October 16, 2018

Nina Ruiz  
PM/Planner II  
El Paso County Planning and Community Development

This letter responds to your MDT Letter uploaded 9/13/18. Our responses to comments are provided in red below.

Regarding Project: Gardens At North Carefree PUDSP File #: PUDSP184 Agency: Central CO Conservation District Project Manager: Nina Ruiz ([NinaRuiz@elpasoco.com](mailto:NinaRuiz@elpasoco.com)) Due Date: 9/11/2018 The Board of Supervisors of the Central Colorado Conservation District have no comments at this time. Thank you Pamela Davison District manager Central Colorado Conservation District 5610 Industrial PI Suite 100 Colorado Springs, CO 80916

2 OF 10

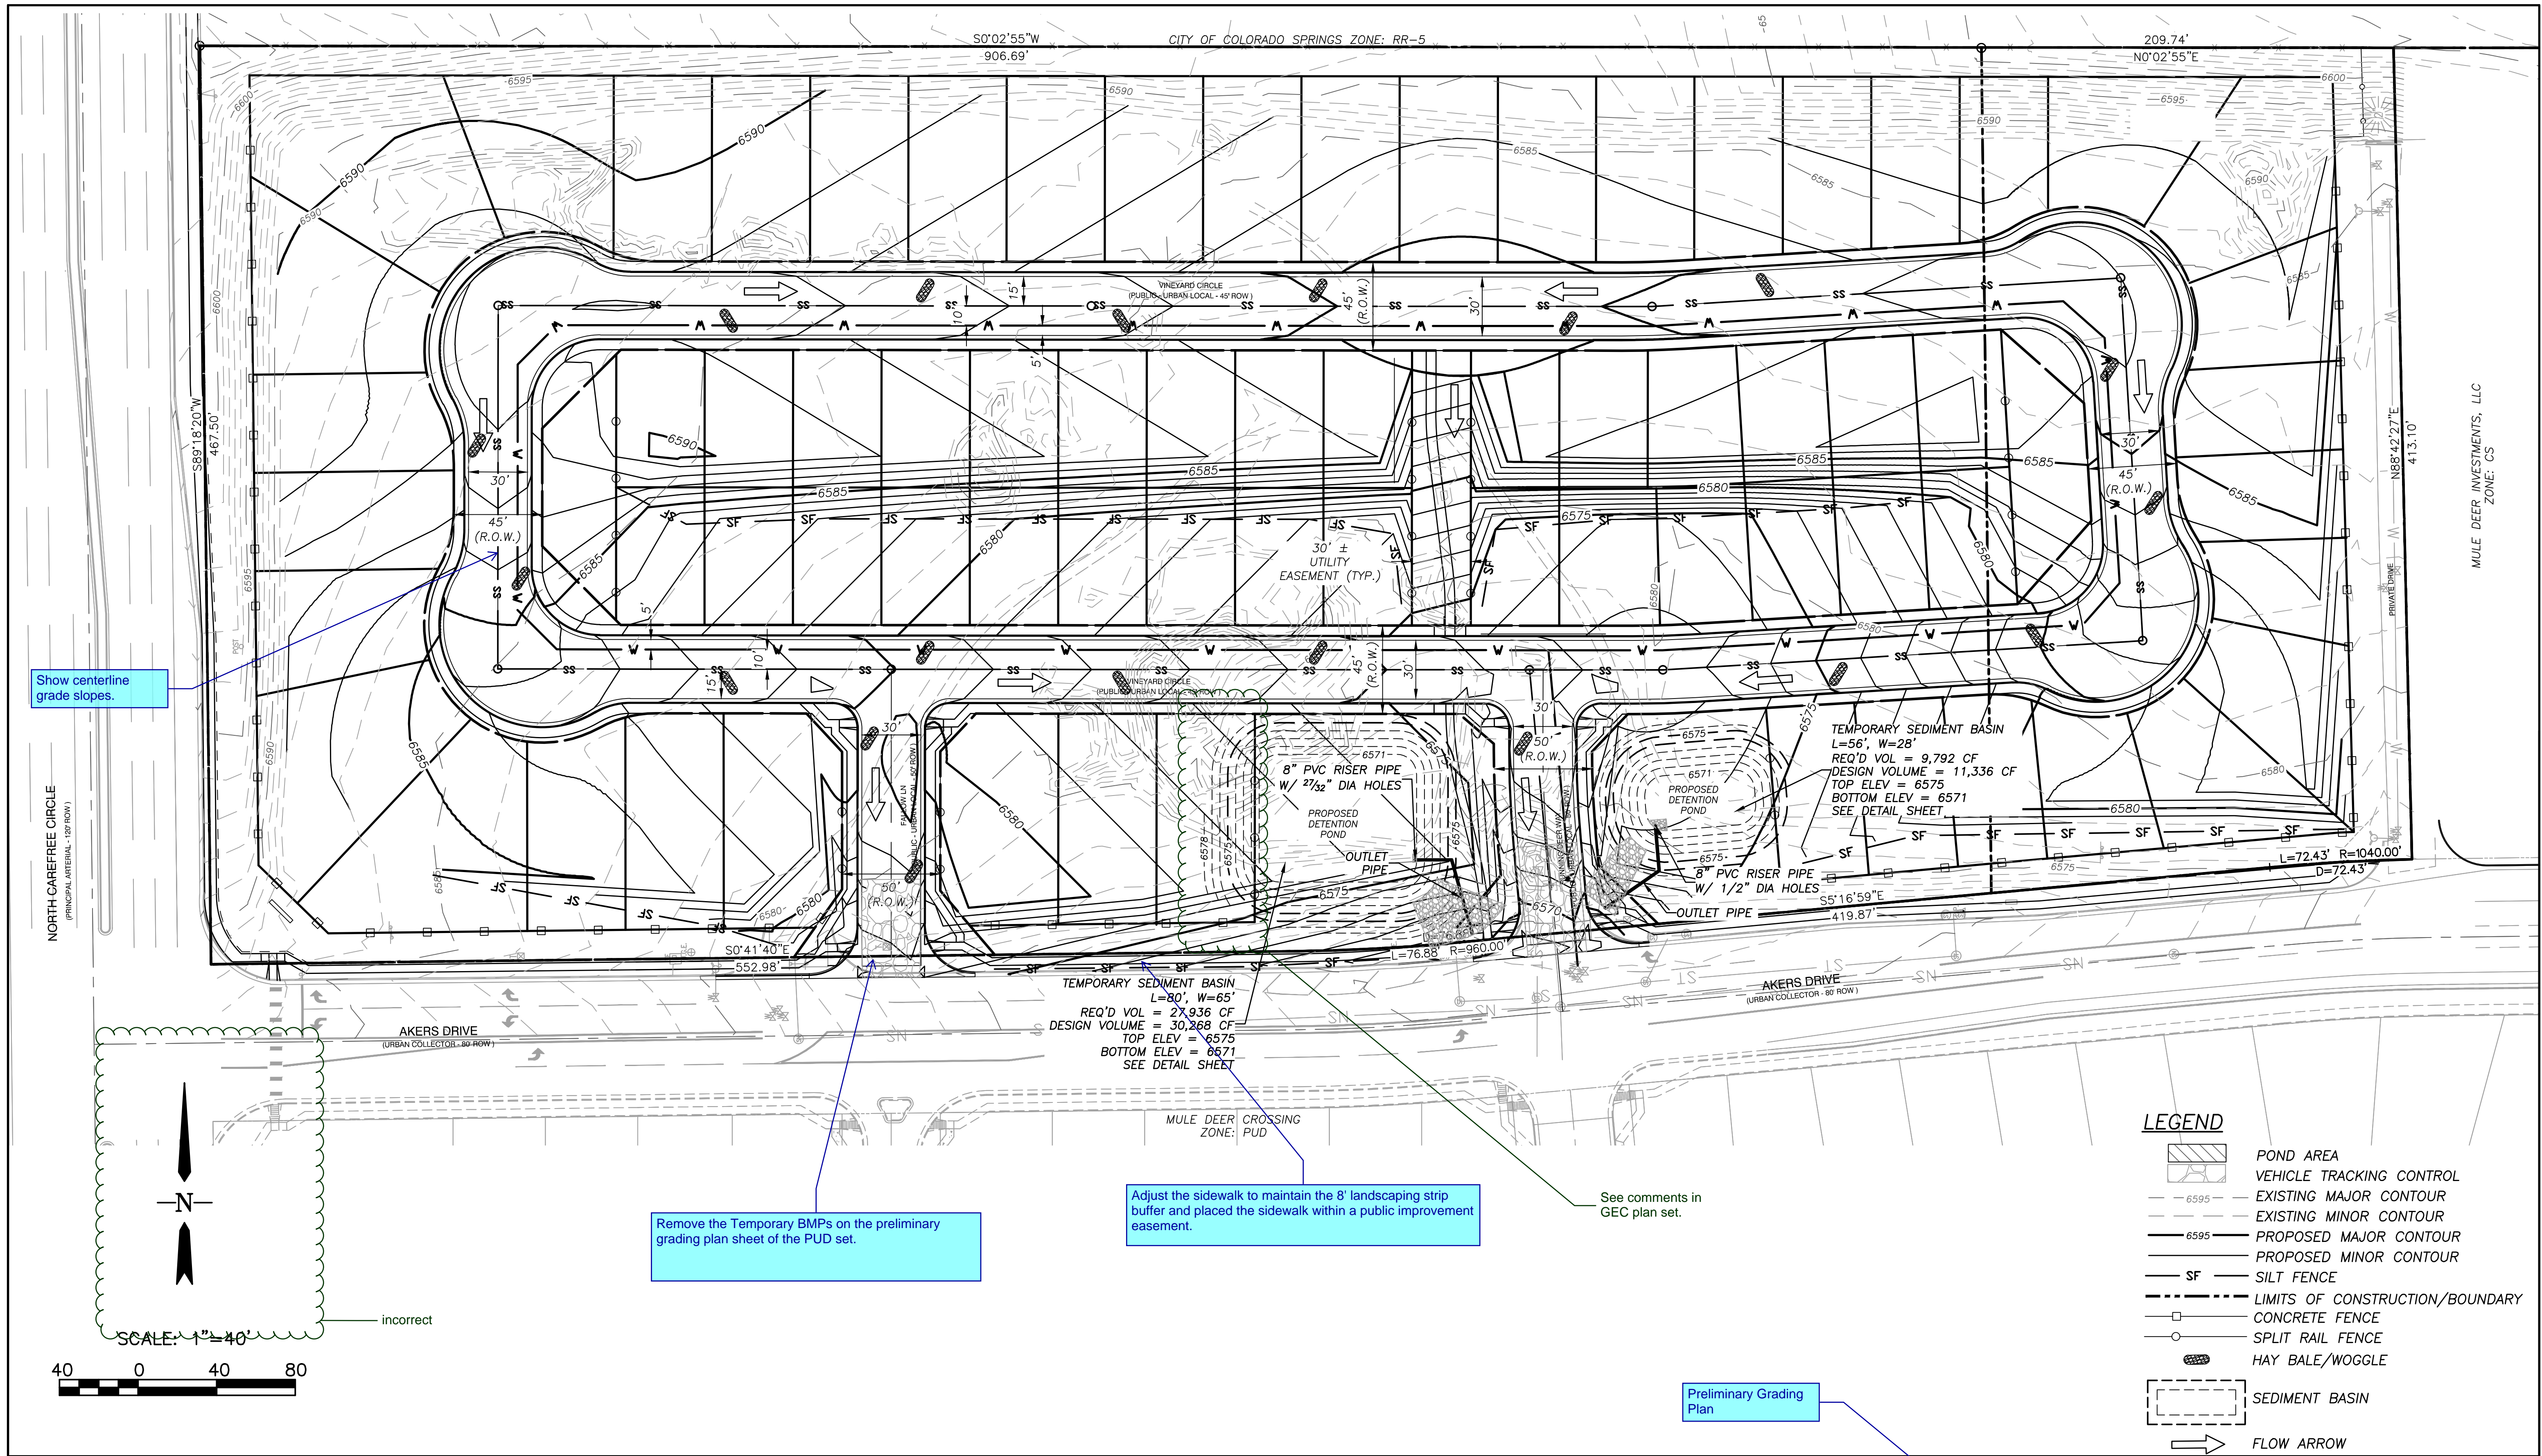
Colorado Geological Survey comments: Grading plan, sheet 3 of 10, Stantec, August 3, 2018:

1. North arrow is incorrect. – **Corrected.**
2. Detention pond contours conflict with proposed site grading contours. – **Grading has been revised accordingly.**
3. Constructed detention pond slopes encroach onto adjacent lots. – **Grading has been updated and the pond does not encroach onto adjacent lot.**
